Application Reference No. 24240/APP/2023/649

**Proposed Extension at 21 The Avenue, Ickenham UB10 8NR
Impact on 19 The Avenue, Ickenham**

Proposal: Conversion of roof space to habitable use to include 5 roof lights and 2 rear dormers. Alterations to roof height and profile. Erection of two storey front, side and rear extensions with amendments to fenestration (revised plans and description)

PROPOSED FRONT ELEVATION

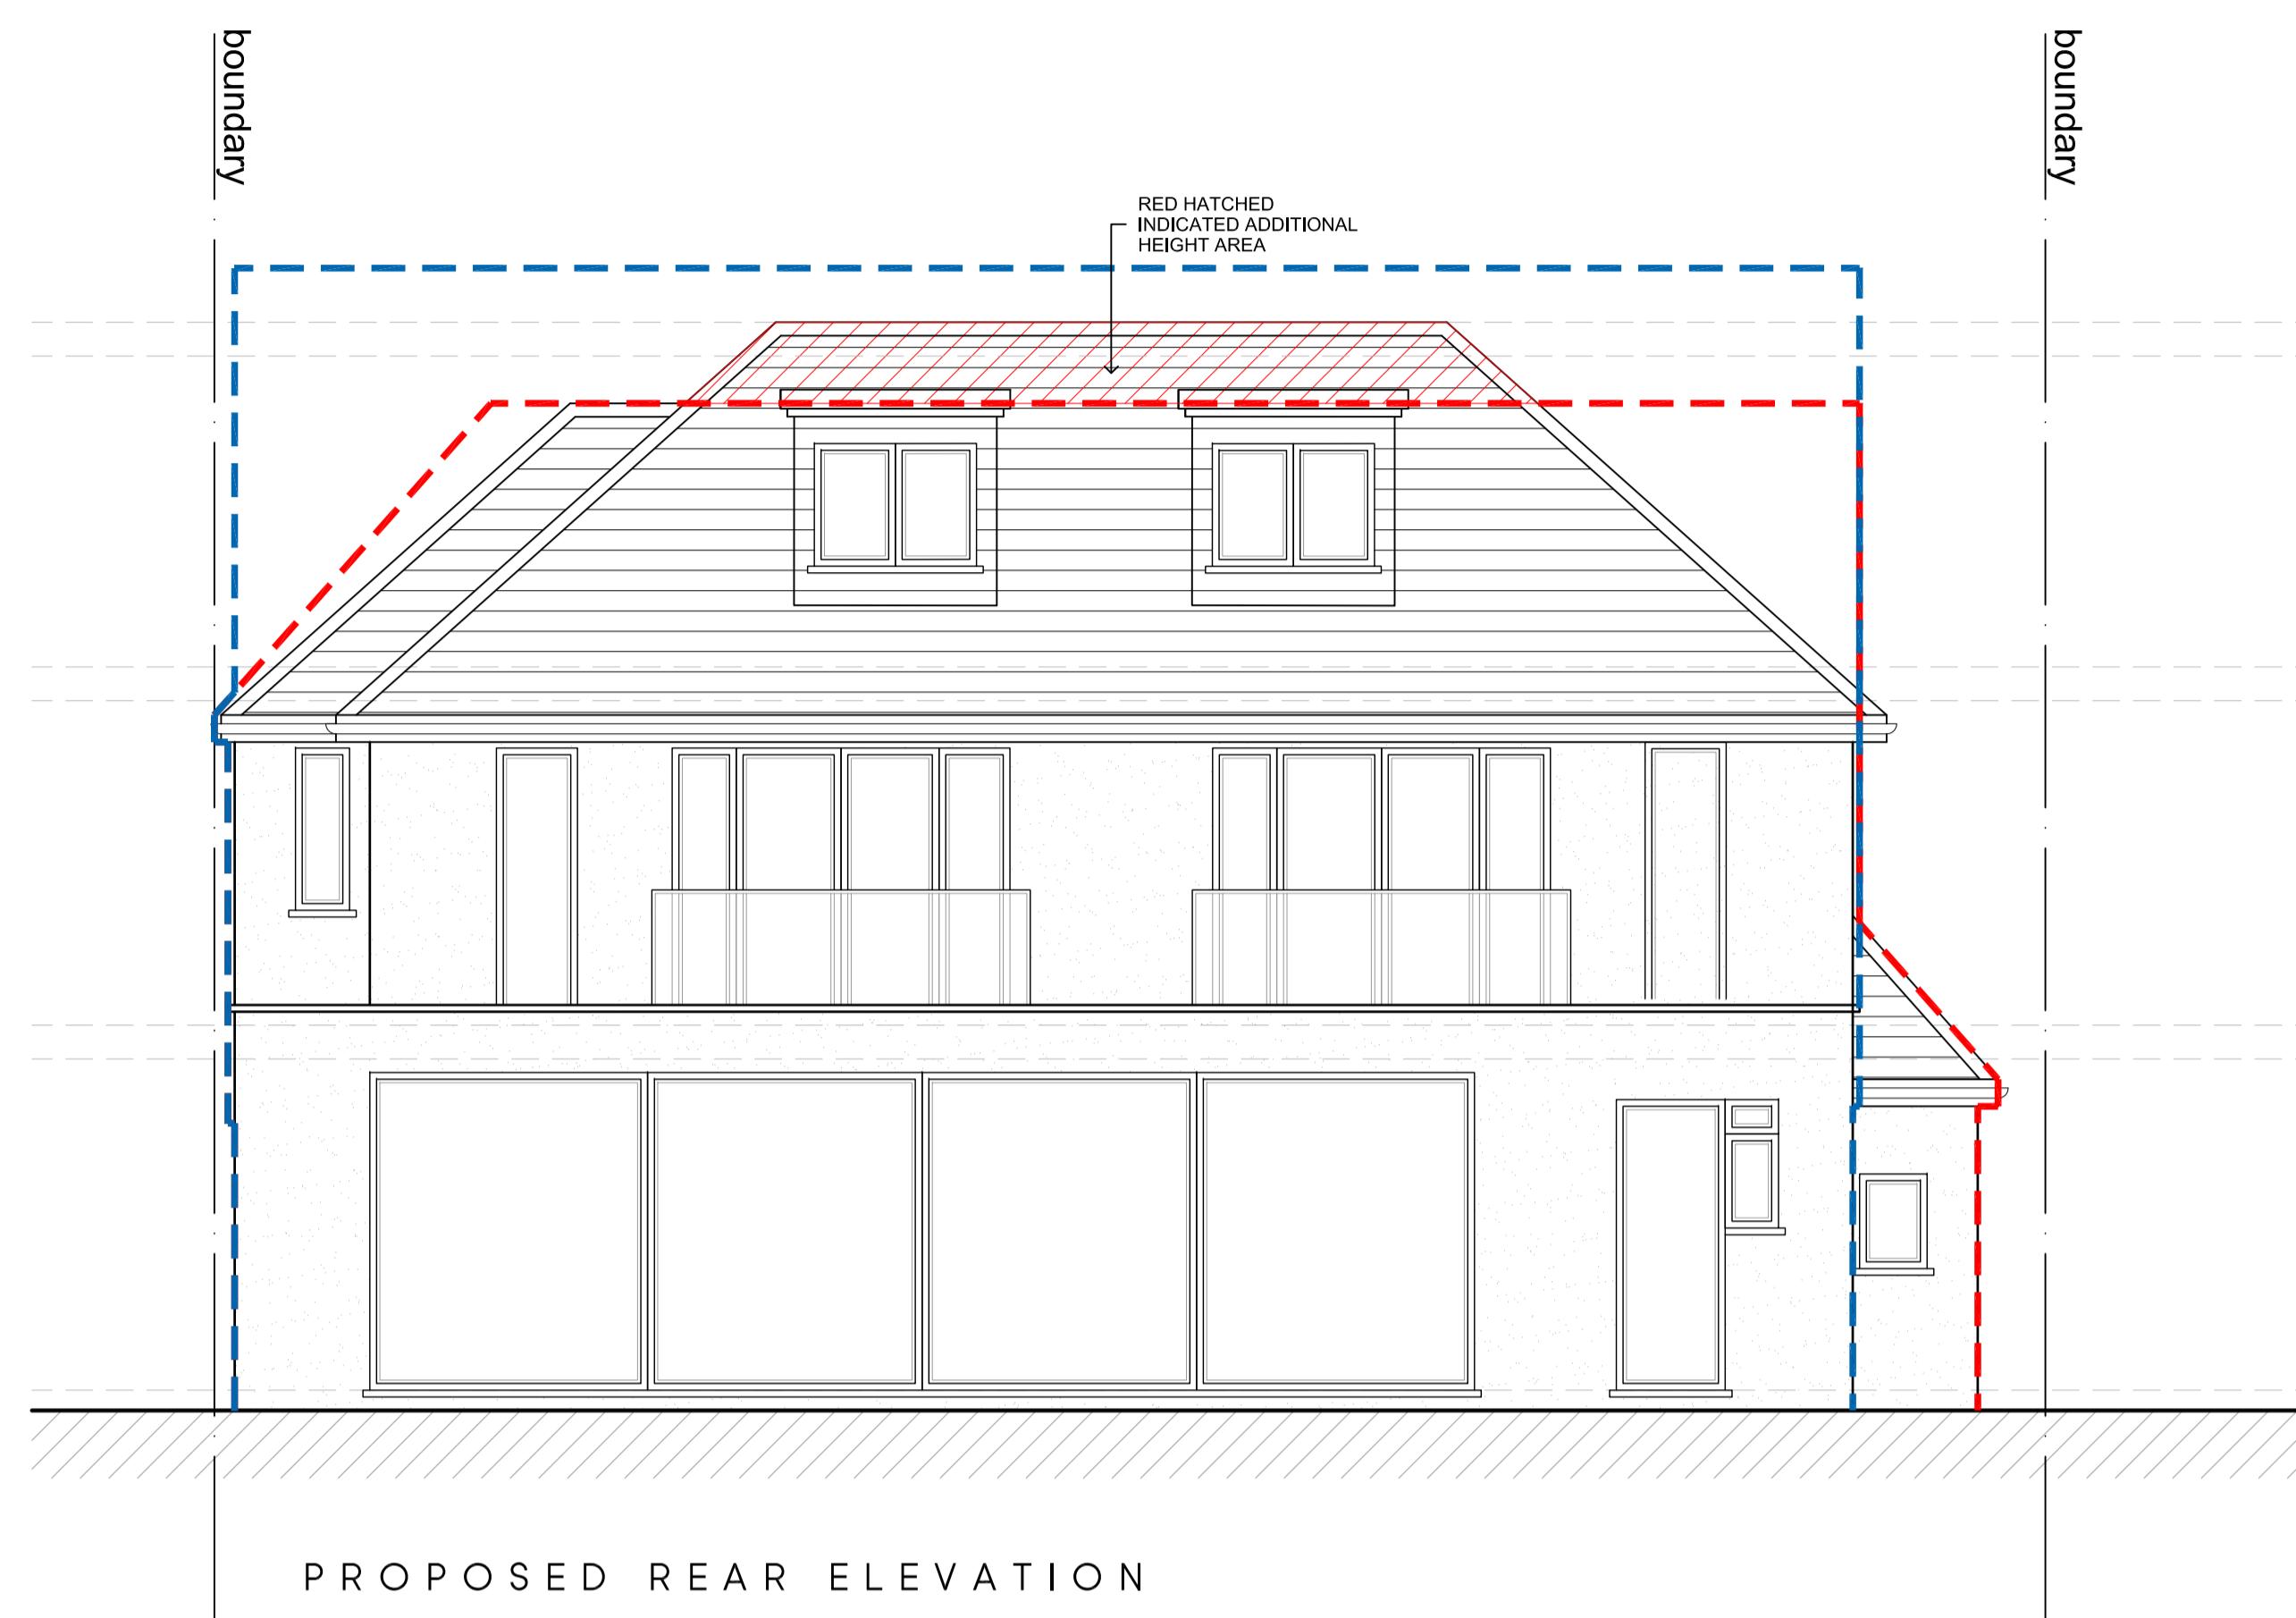
The application drawings for the proposed extension to No. 21 The Avenue include plan drawings showing the relationship of the proposal with the rear living room main window at No. 19 The Avenue. However, we have been able to plot the approximate position of the centre of the window on the proposed front elevation drawing of No. 21. It is evident from the drawing below that the proposed extension does not satisfy the 25° test.
